Application for Planning Permission for Works or Extension to a Dwelling

Development: Part single, part two storey front, side and rear extensions, loft conversion including the installation of 1 No. front and 1 No. rear dormers.
Location: 69 Crossbush Road Felpham PO22 7LY

Proposed Roof Plan

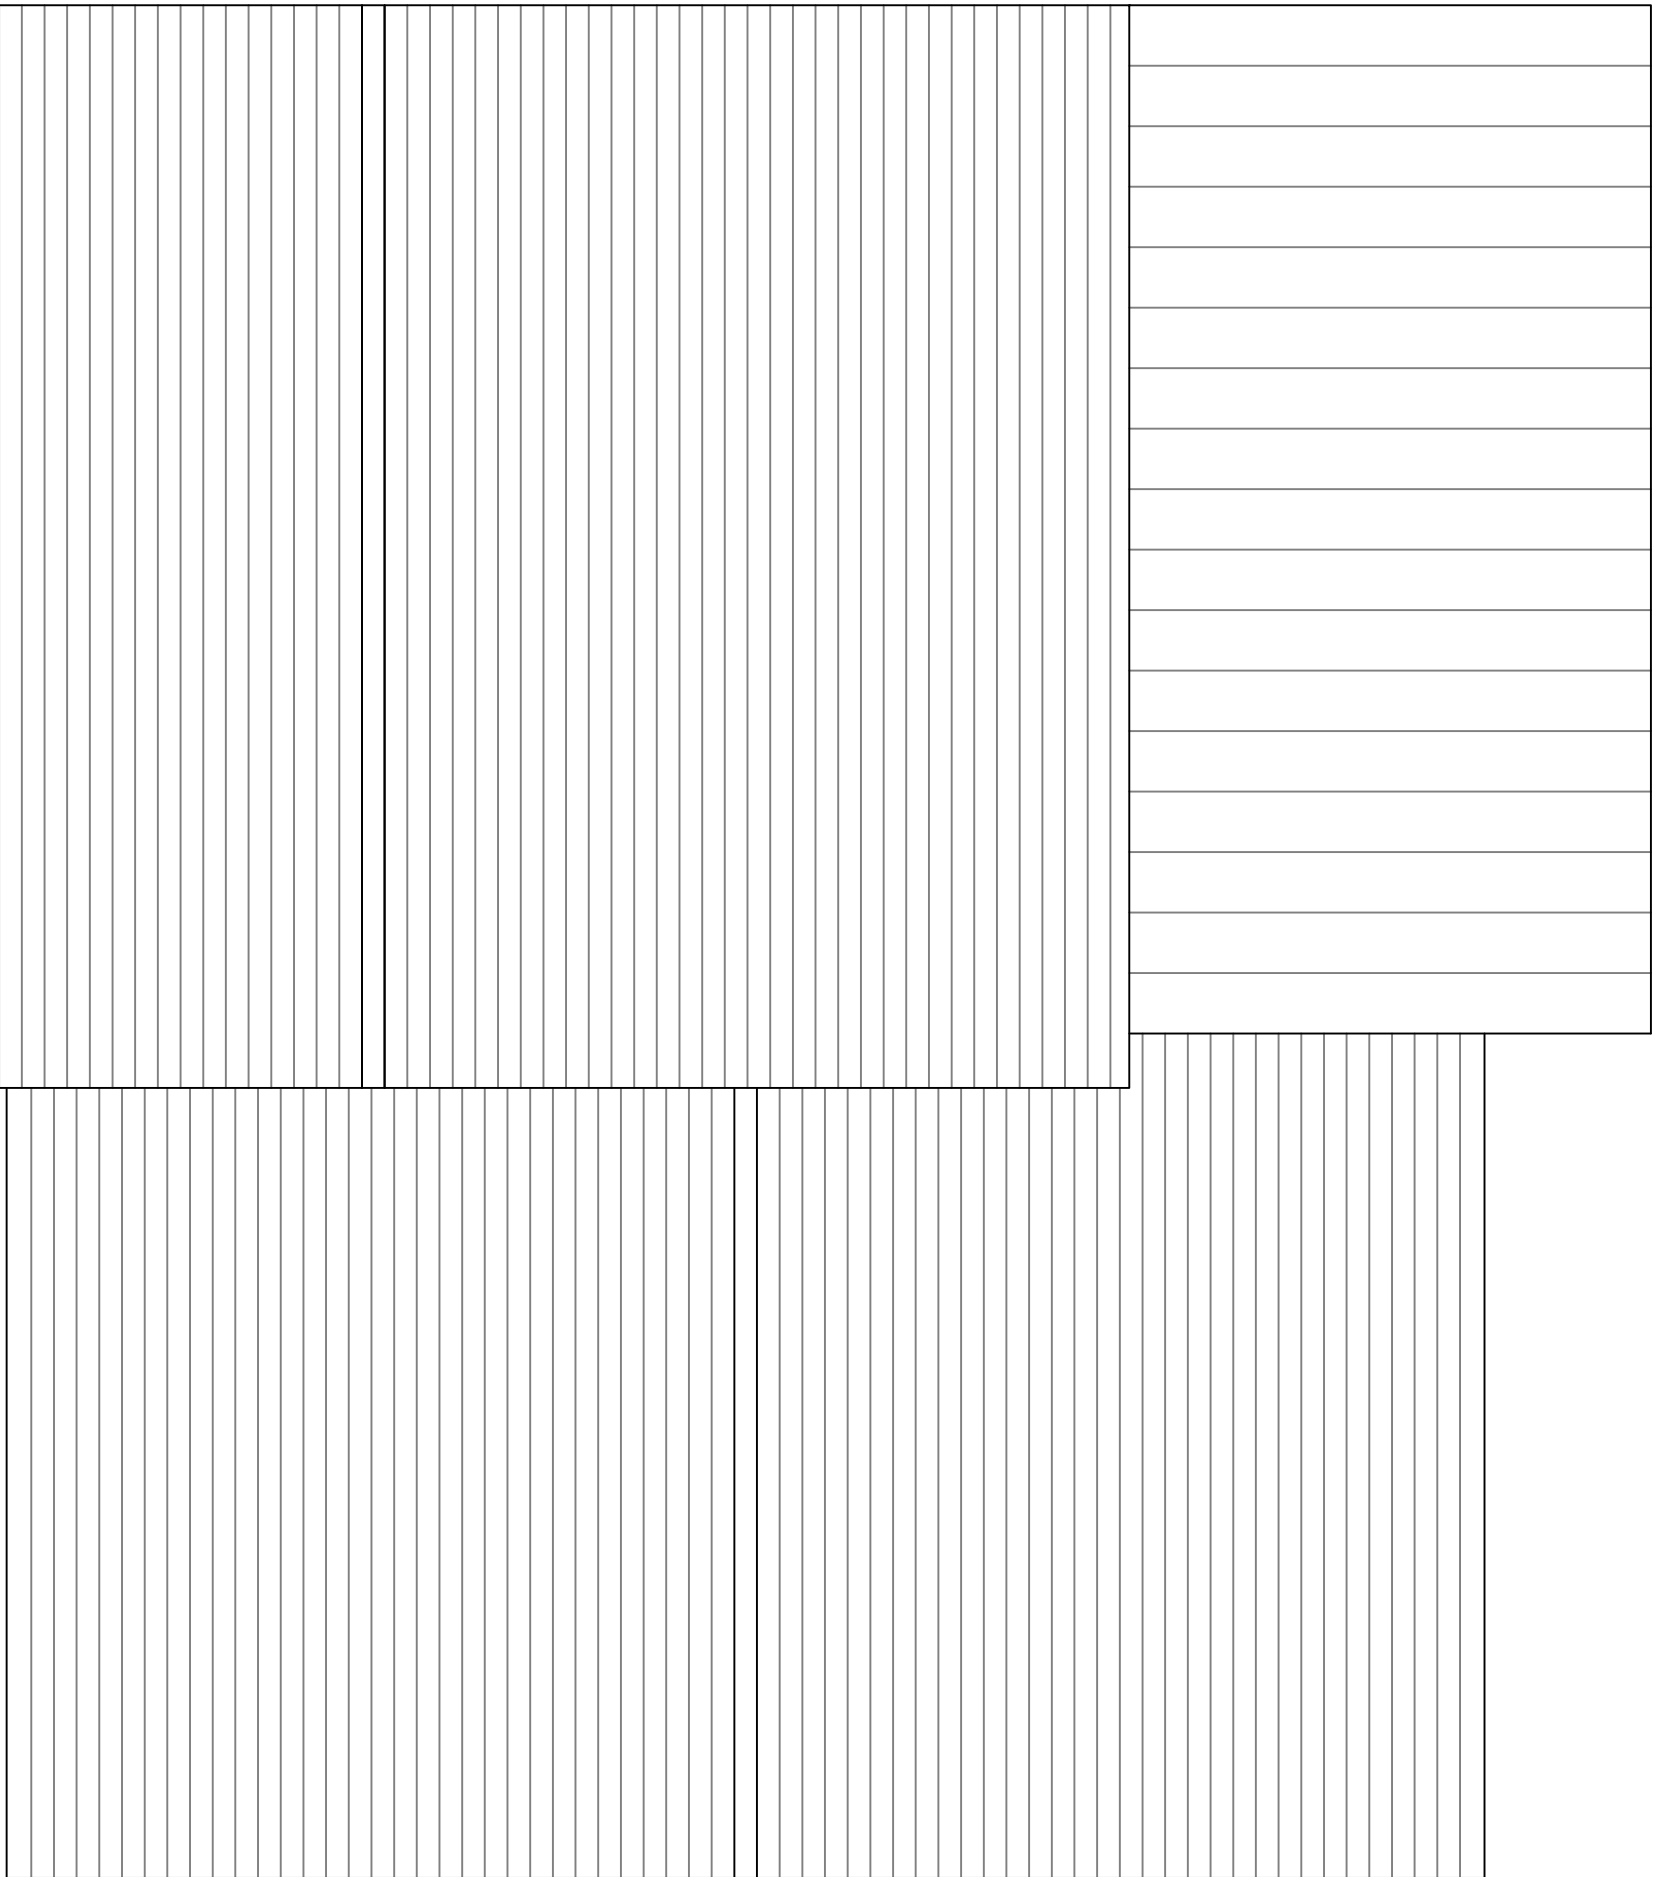
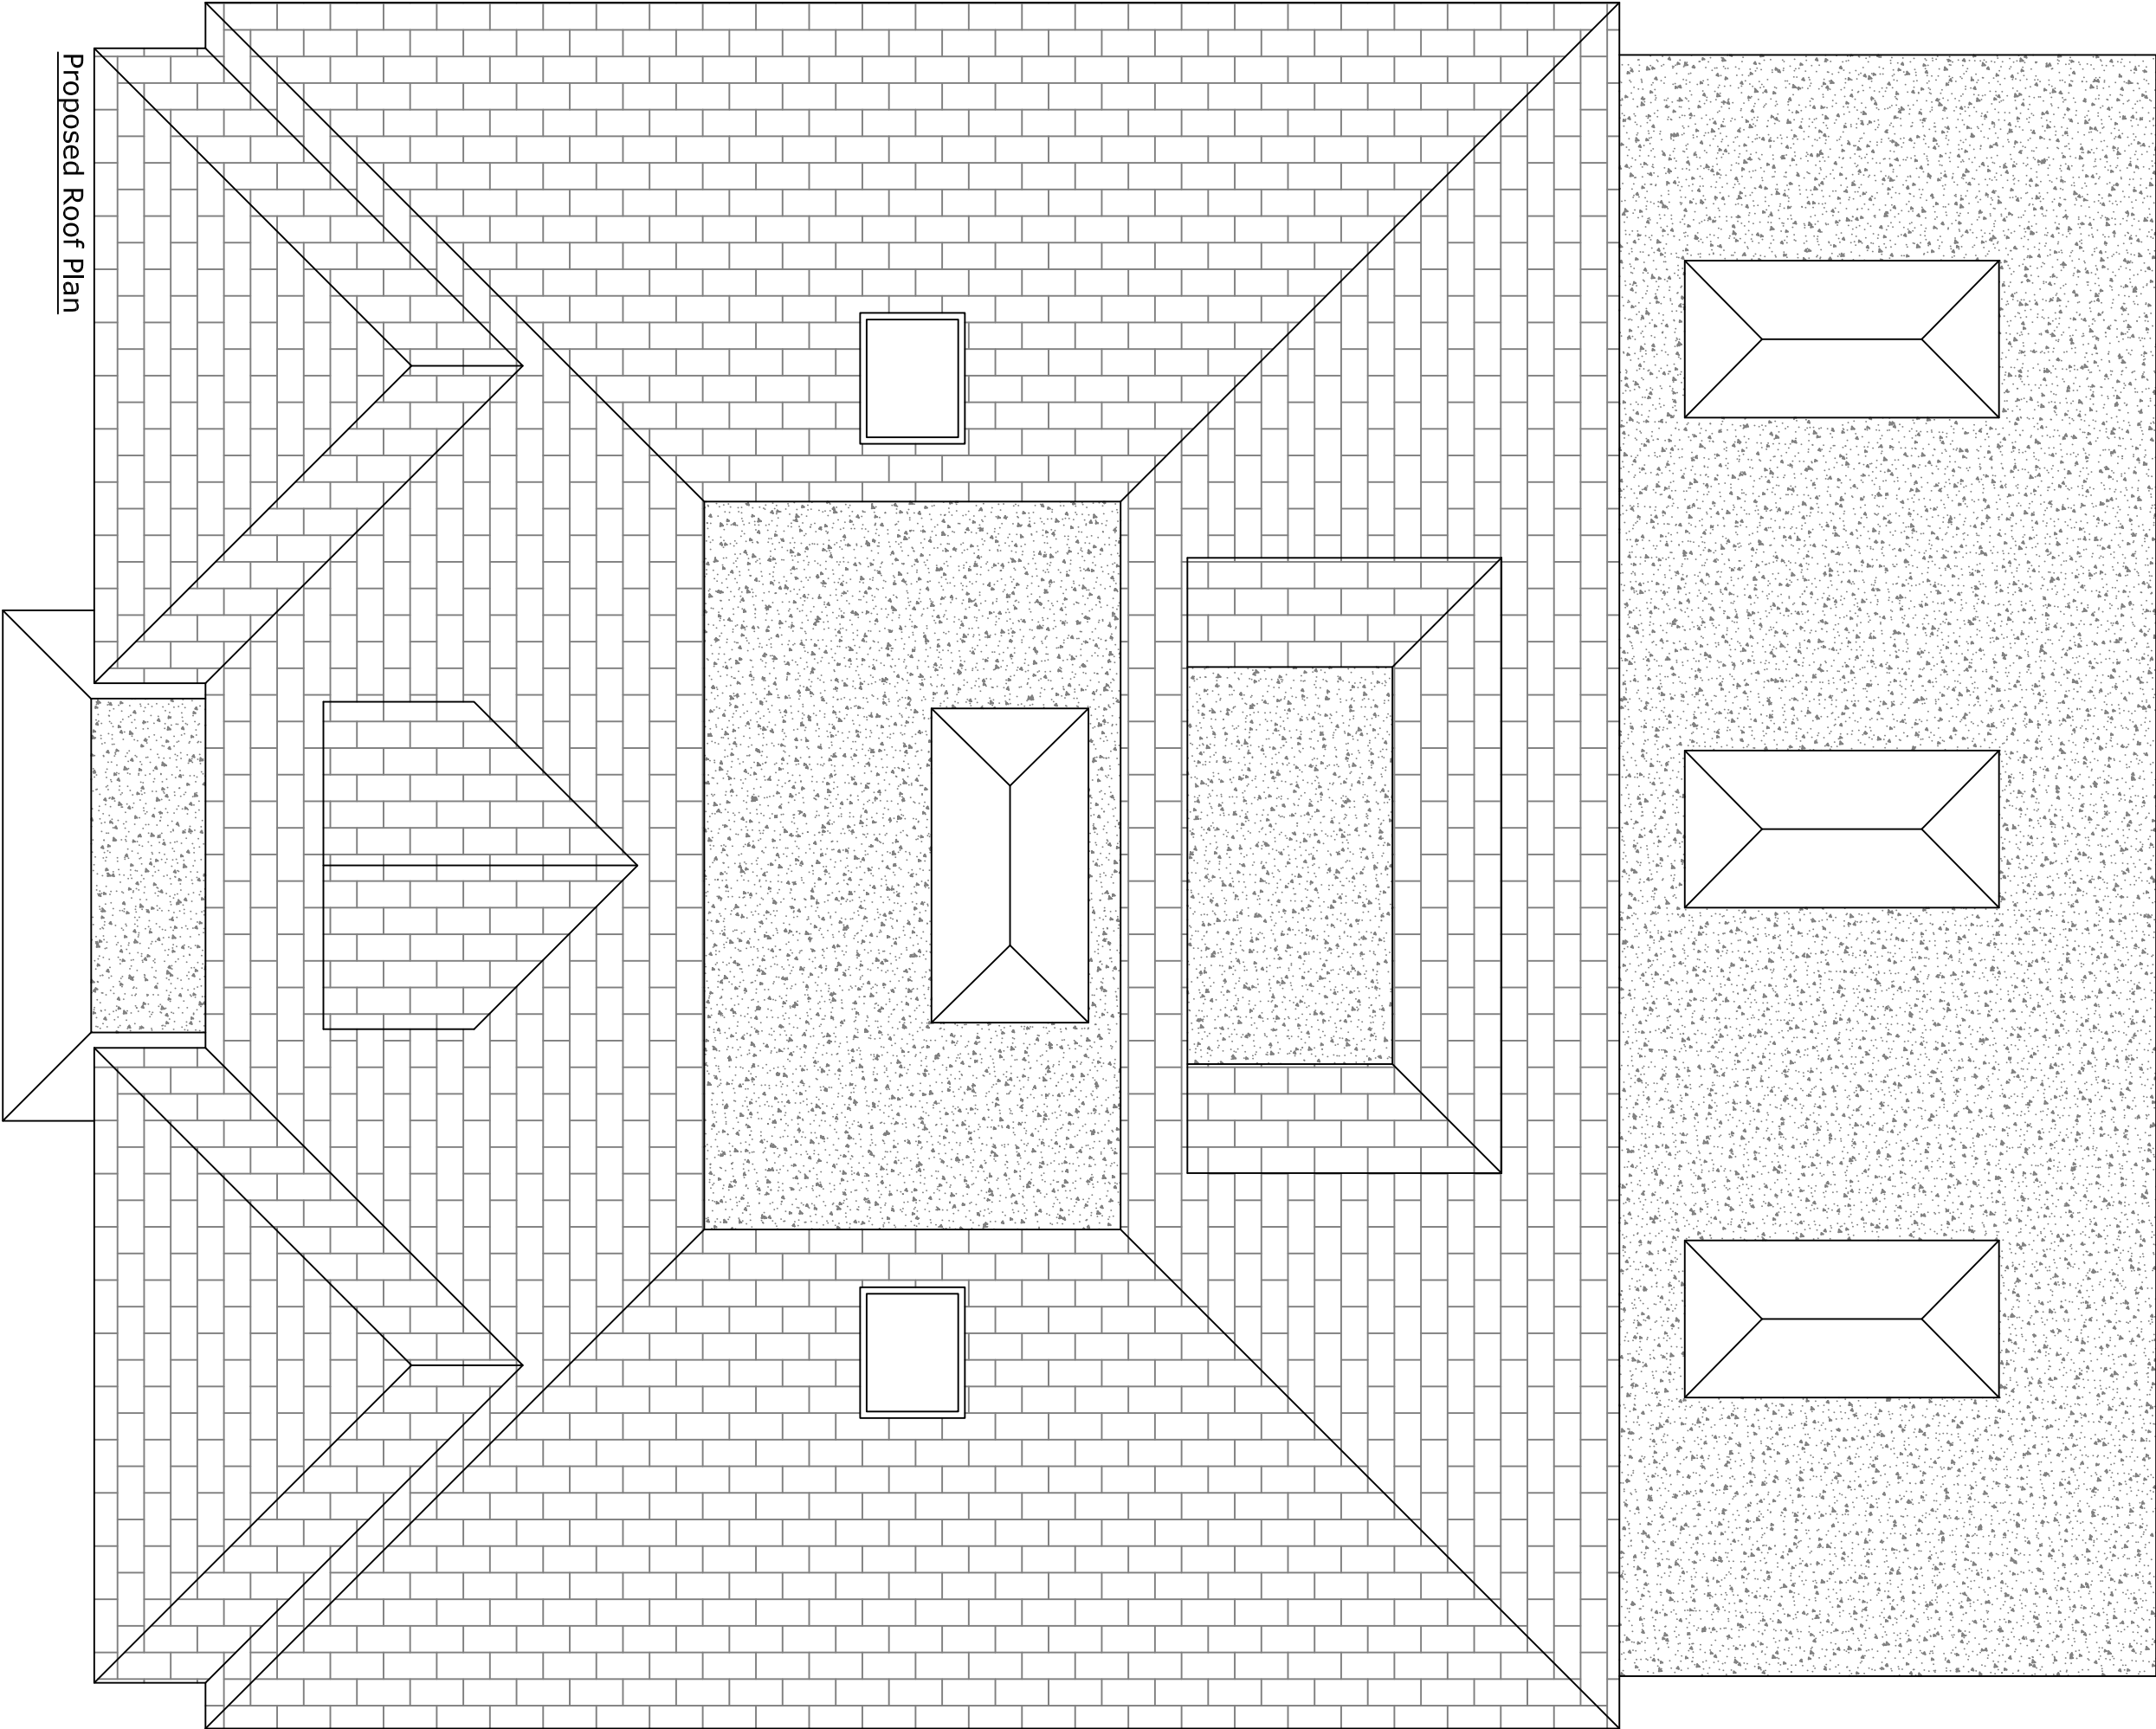
No roof plans have been provided, please amend.
